**Consultation Response from KC,
Highways Development Management****2023/92695 Crown Buildings, Scott Hill, Clayton West, Huddersfield, HD8 9PE****Change of use and alterations to workshop to create two dwellings****Date Responded: 31-10-2023.****Responding Officer: Mark Berry****Responding Ref: 17-39-13.**

This application seeks approval to the change of use and alterations to workshop to create two dwellings at Crown Buildings, Scott Hill, Clayton West, Huddersfield.

3 Site Plan as Proposed
1 : 100

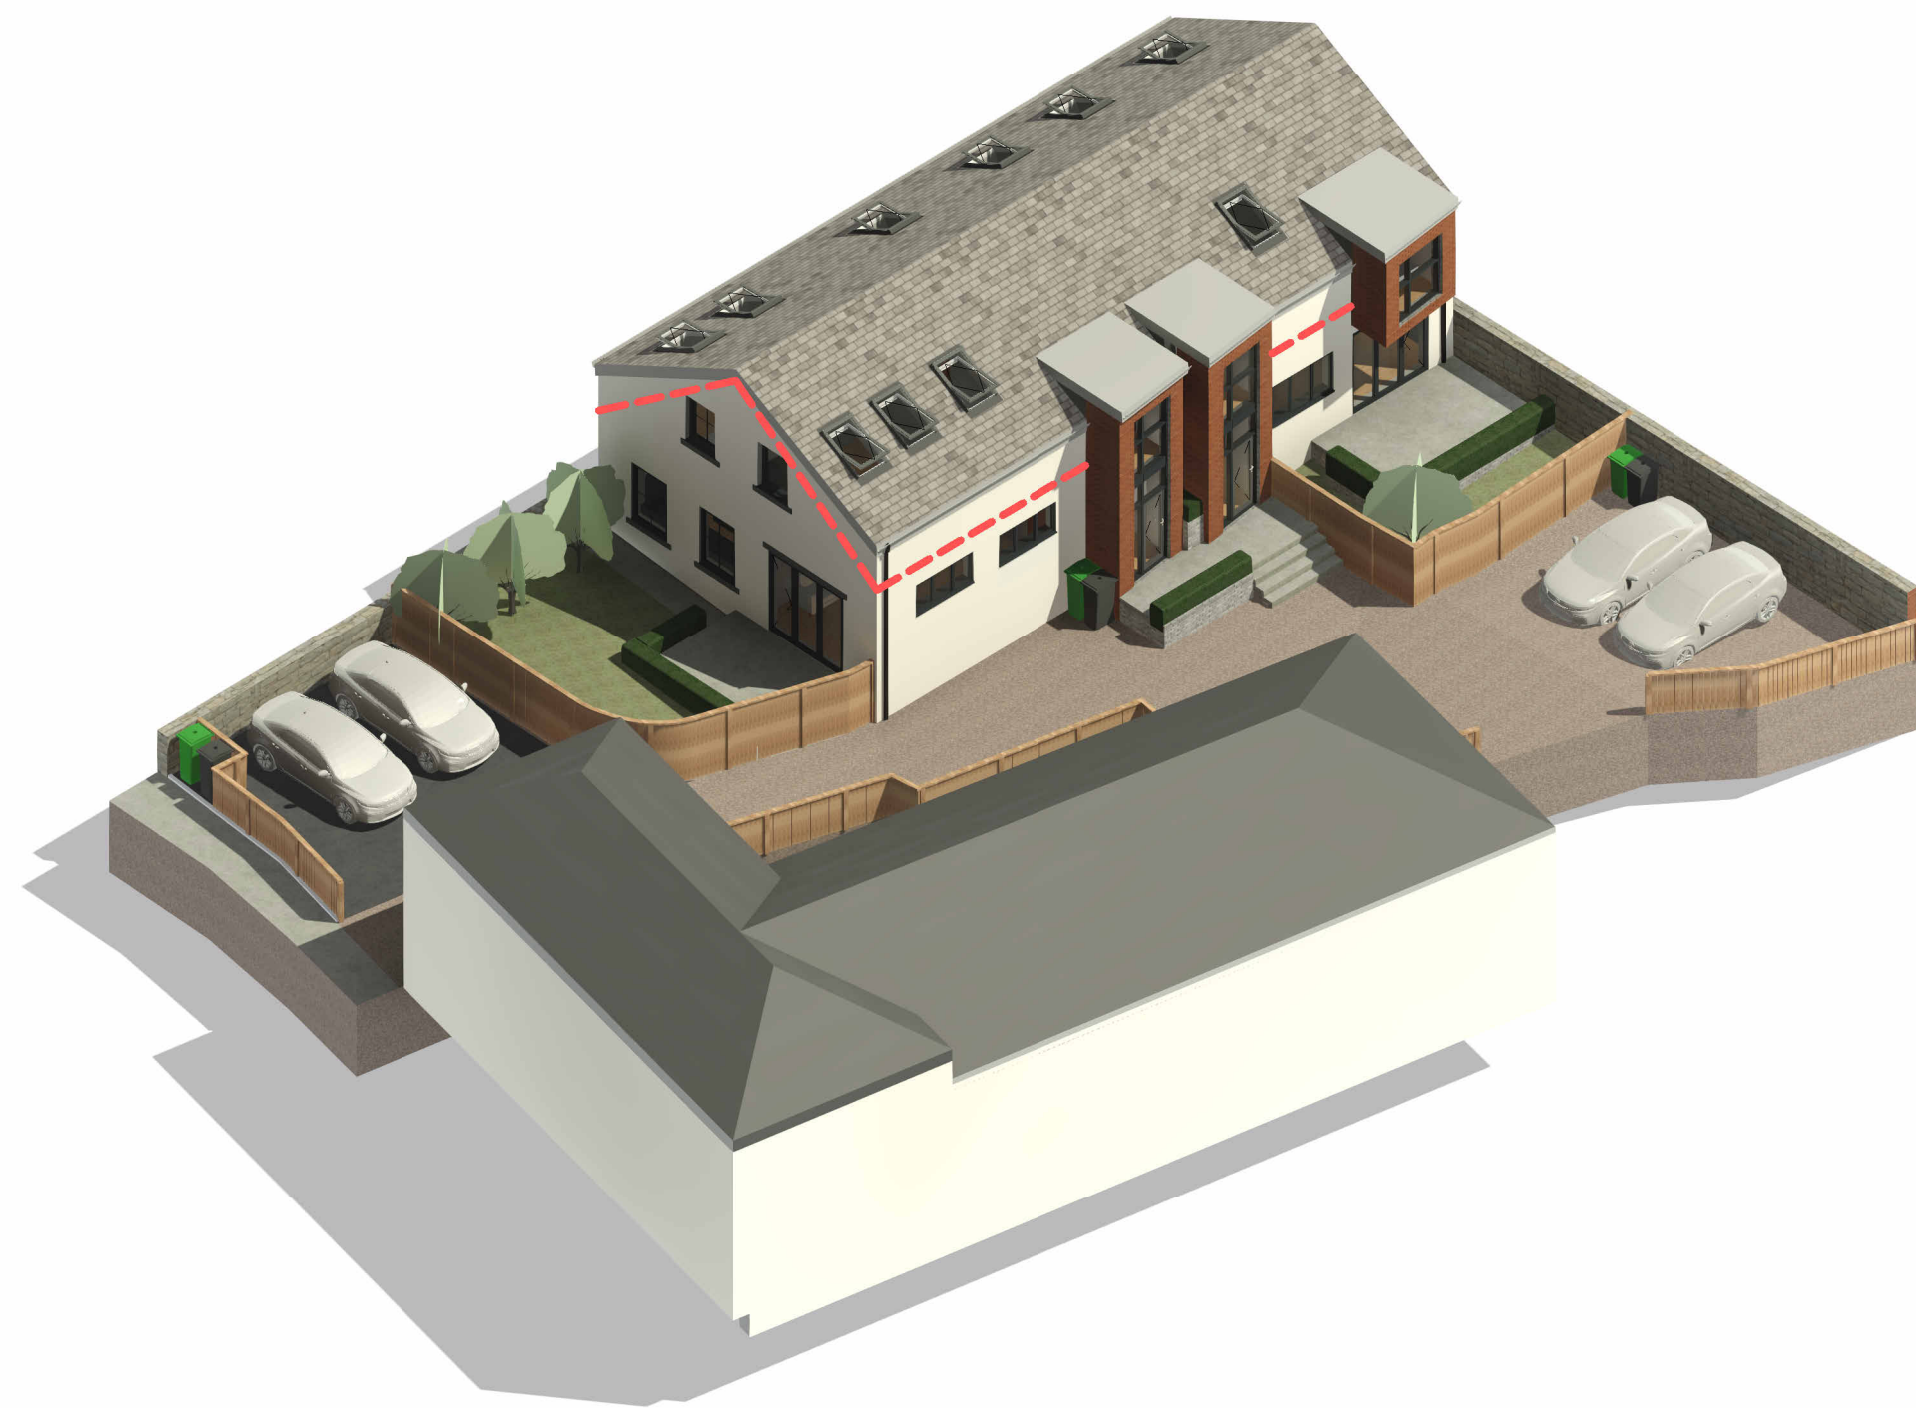
1, The applicants should show the proposed sight lines from the site access onto Scout Hill. 2.4 x 43m is recommended.

Given that the proposed offices could be used as bedrooms this proposal should show that each dwelling as 3 off-street parking spaces.

3, Swept paths should be provided which demonstrate that a vehicle can enter and exit the site in a forward gear from Scout Hill.
